170 Slater Street

UDRP Report and Response to UDRP Recommendations
April 10, 2024

**RE: Urban Design Review Panel Recommendation Responses
PC2023-0379
170 Slater Street – Site Plan Control**

NORTH SIDE FACADE
IN THE INTERIM
PERIOD BETWEEN
THE FRIST PHASE
AND SECOND PHASE

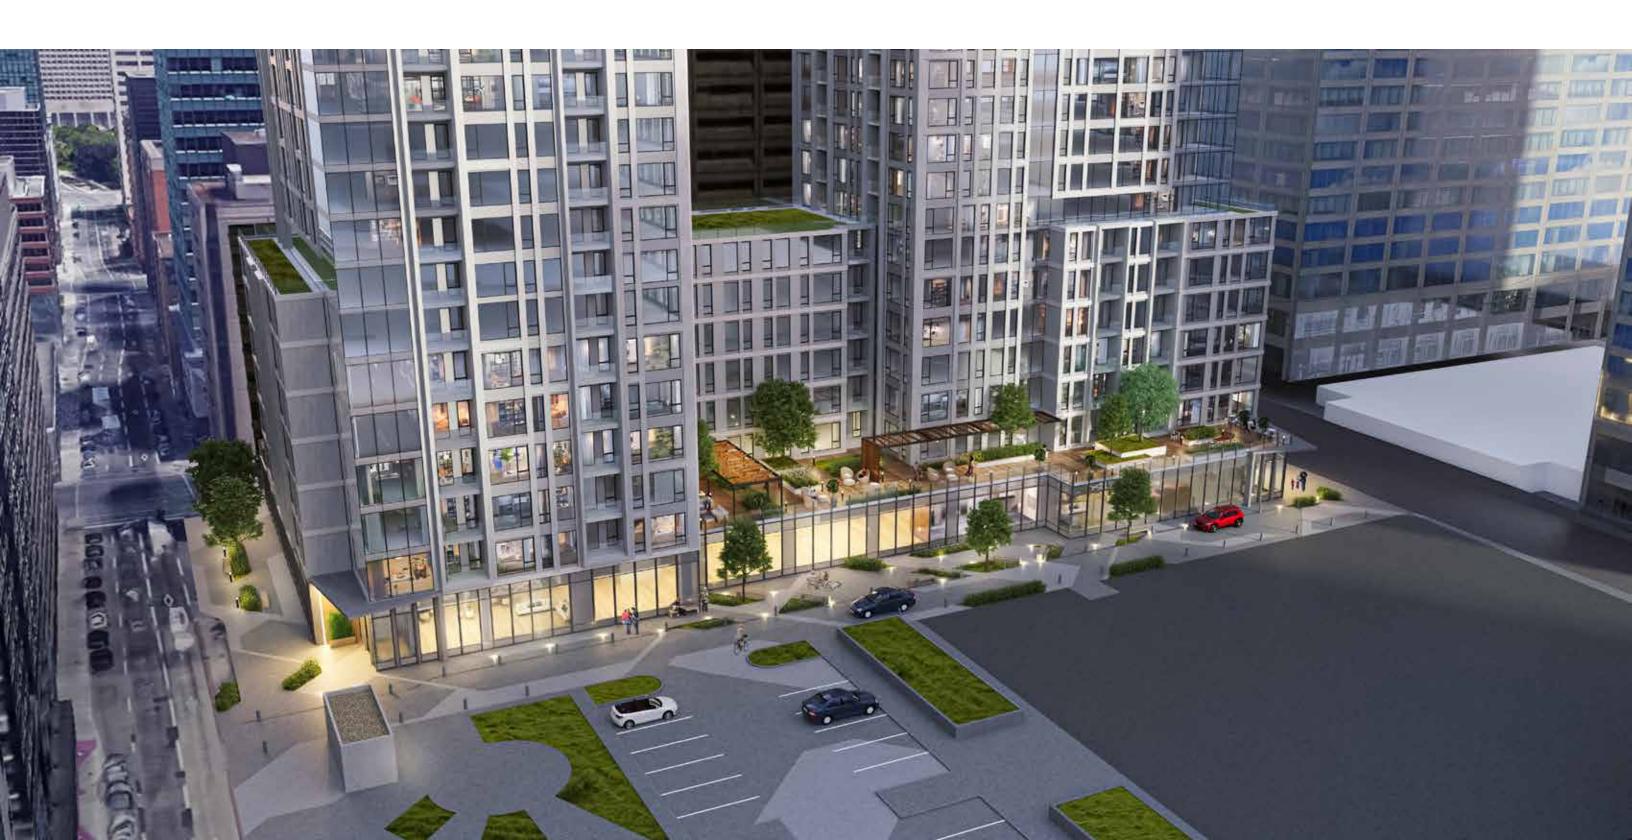
- 8 The Panel recommends carefully considering the interim period between the first and second phases of development in terms of how interim facade conditions and the at-grade areas are treated/animated.
 - / Consider a phasing strategy that enhances the spaces in the interim, such as having an art wall on the north side and a temporary POPS.
 - / Consider options other than surface parking for the interim landscaping phase.
 - / The Panel supports the idea of adding a large mural, that idea would mesh well with a public open space.

Please see the accompanying updated Site Plan, which identifies the proposed interim condition for the undeveloped area, prior to Phase 2.

Drawing title / Titre du dessin: SOUTH TOWER ELEVATIONS

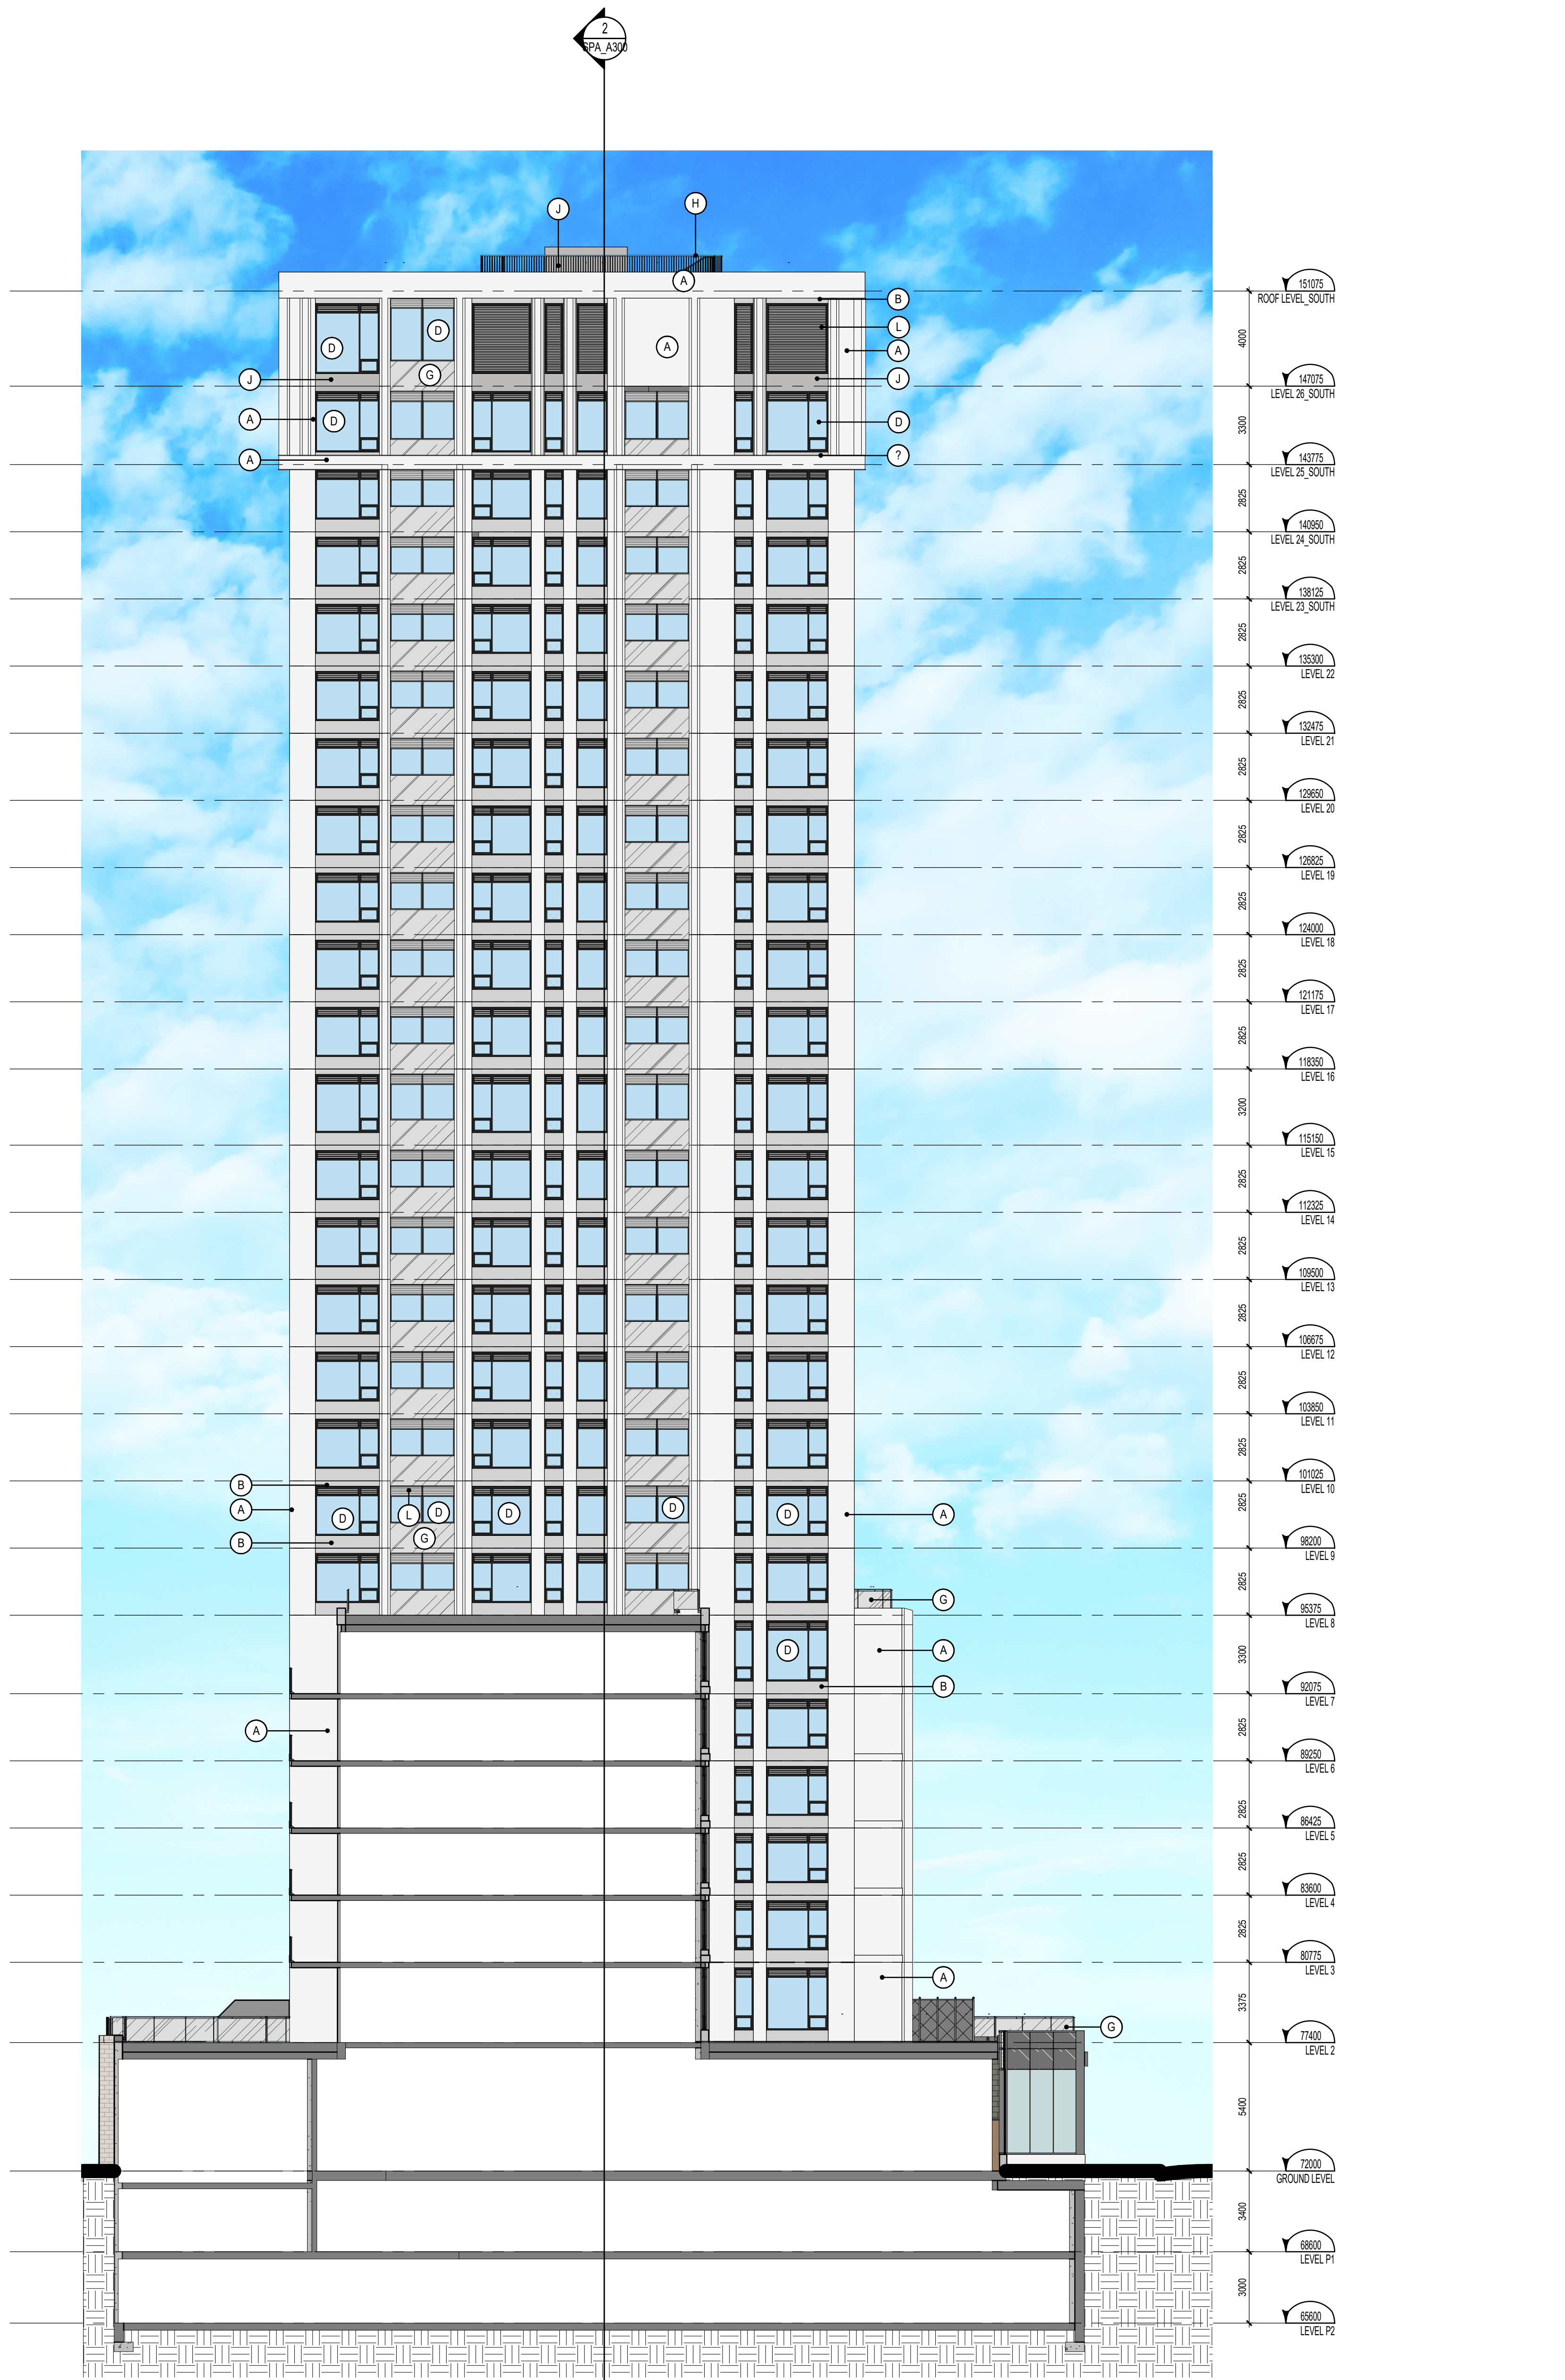
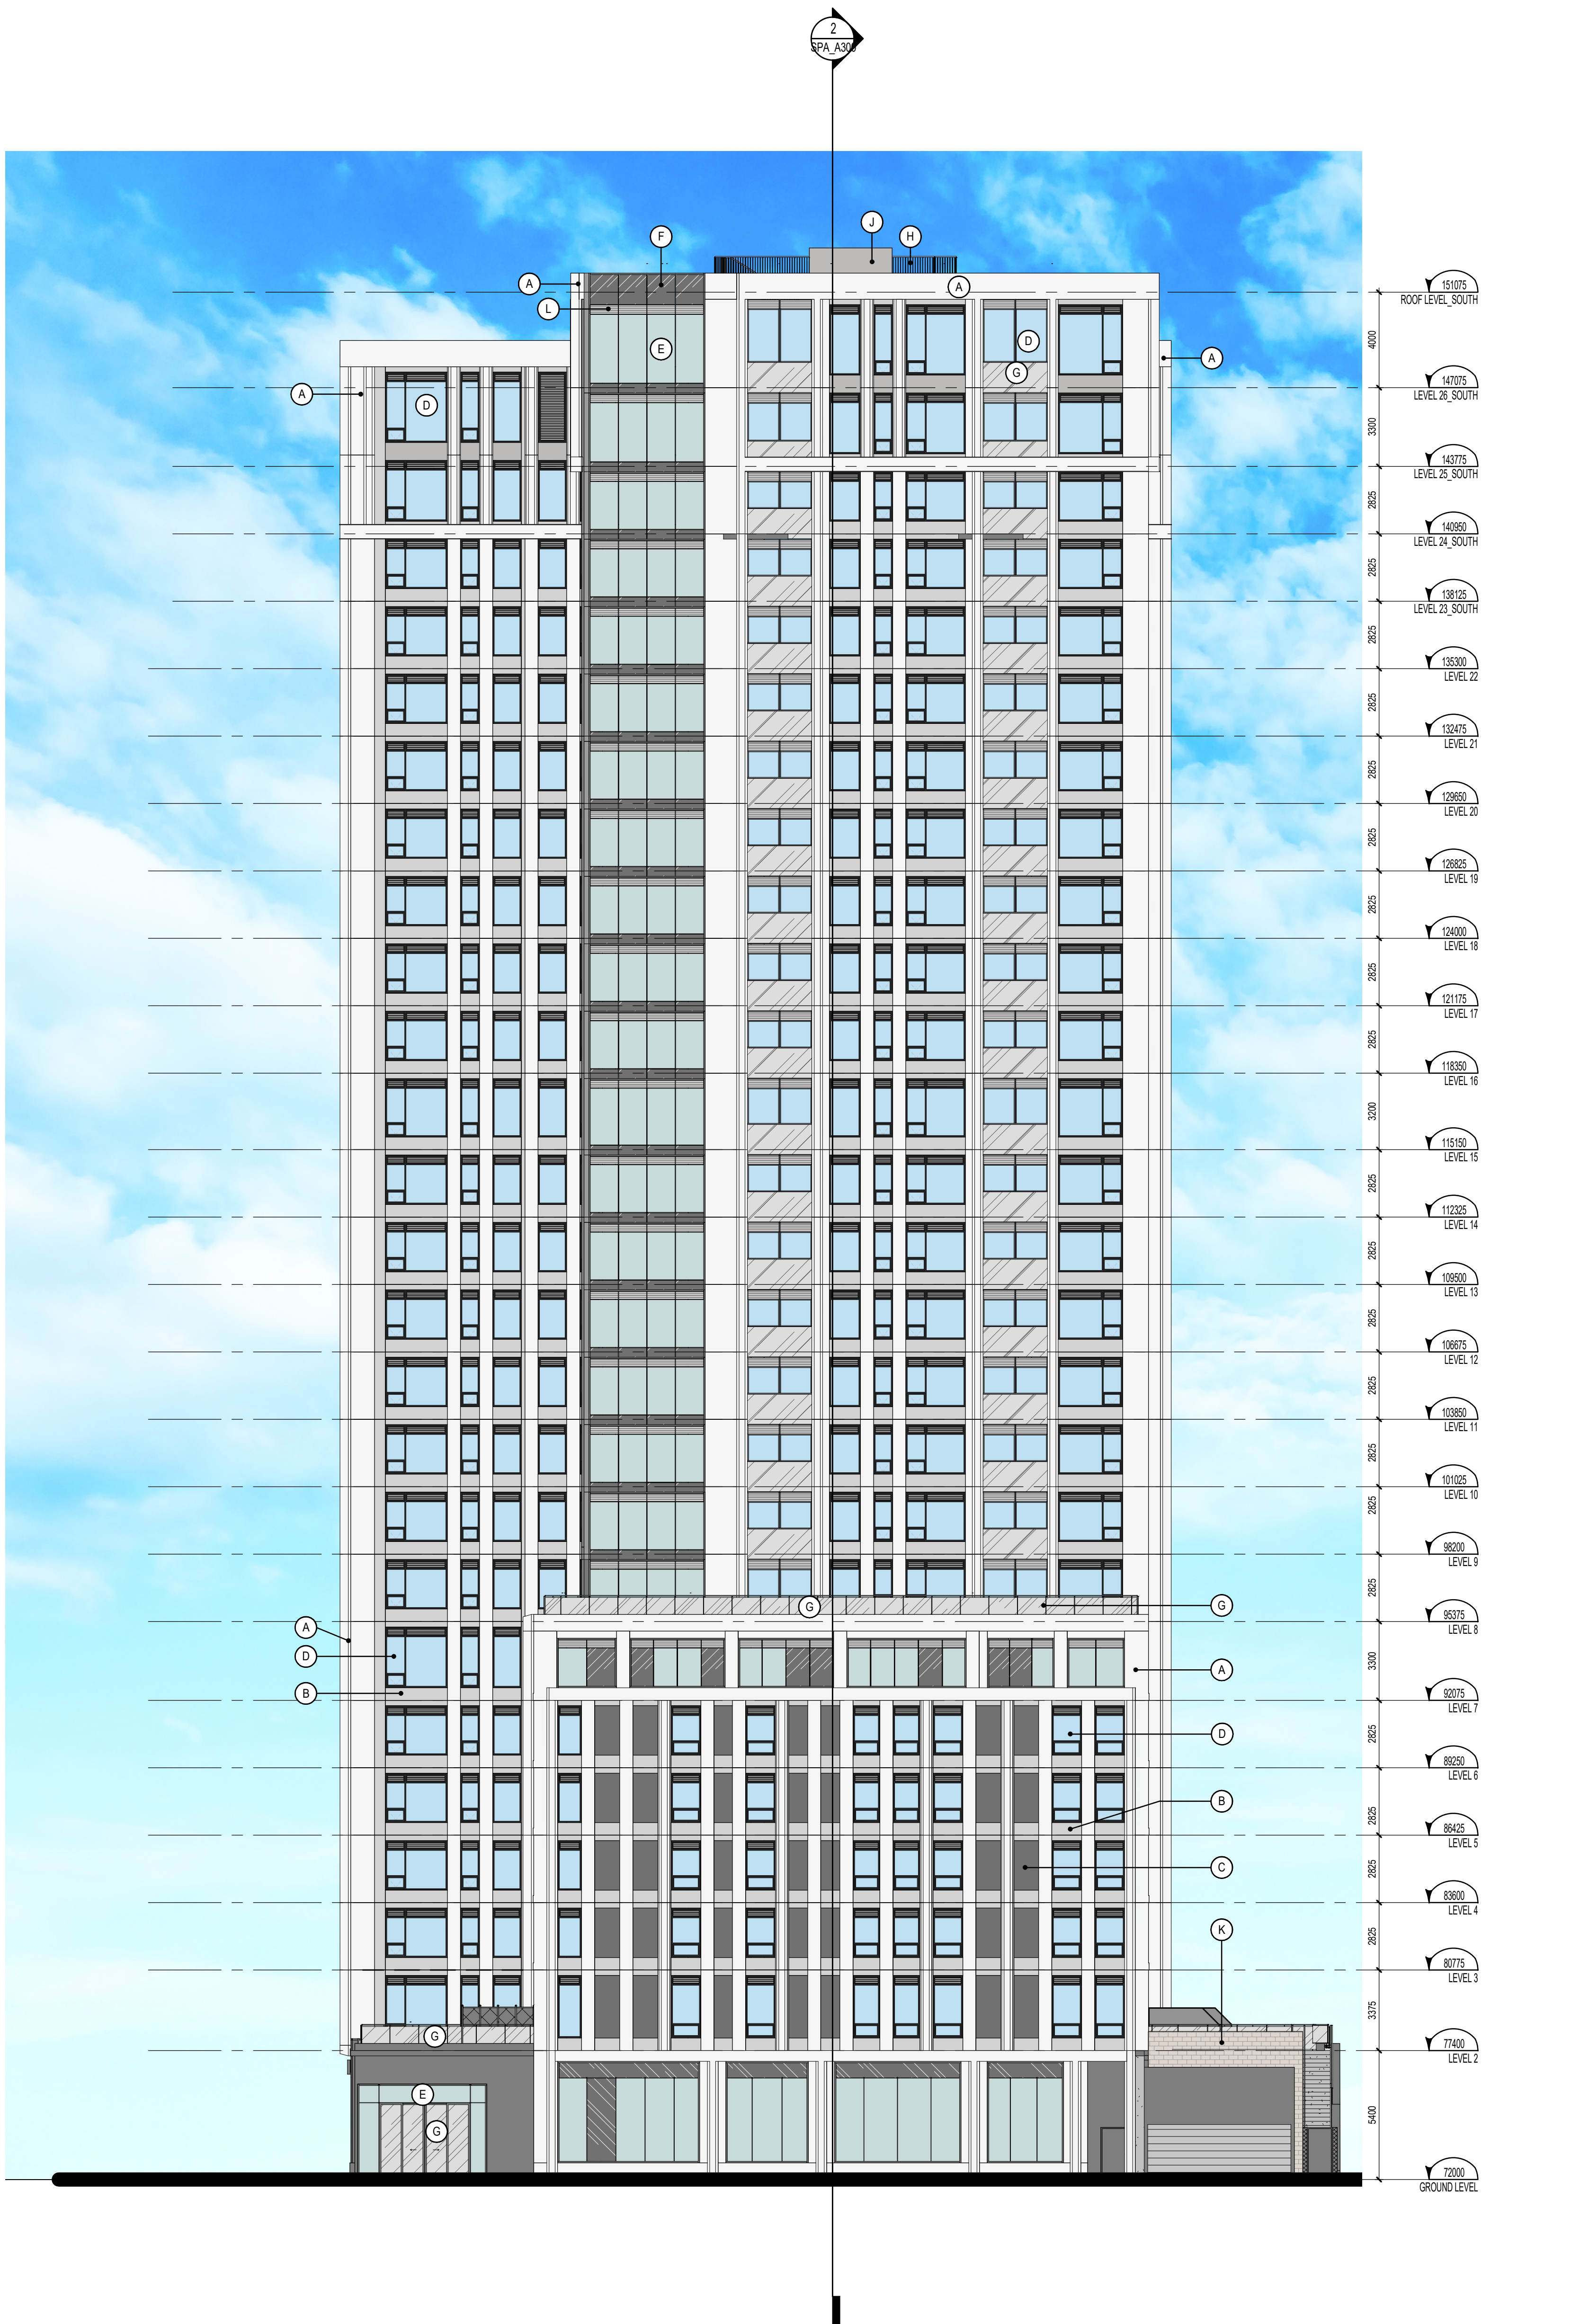
30 The Panel has concerns with the dark colours of the materials as viewed in the renderings and perspectives.

/ Consider pursuing lighter coloured materials as shown in many of the inspirational images on page 8.

The material has been updated to a lighter colour.
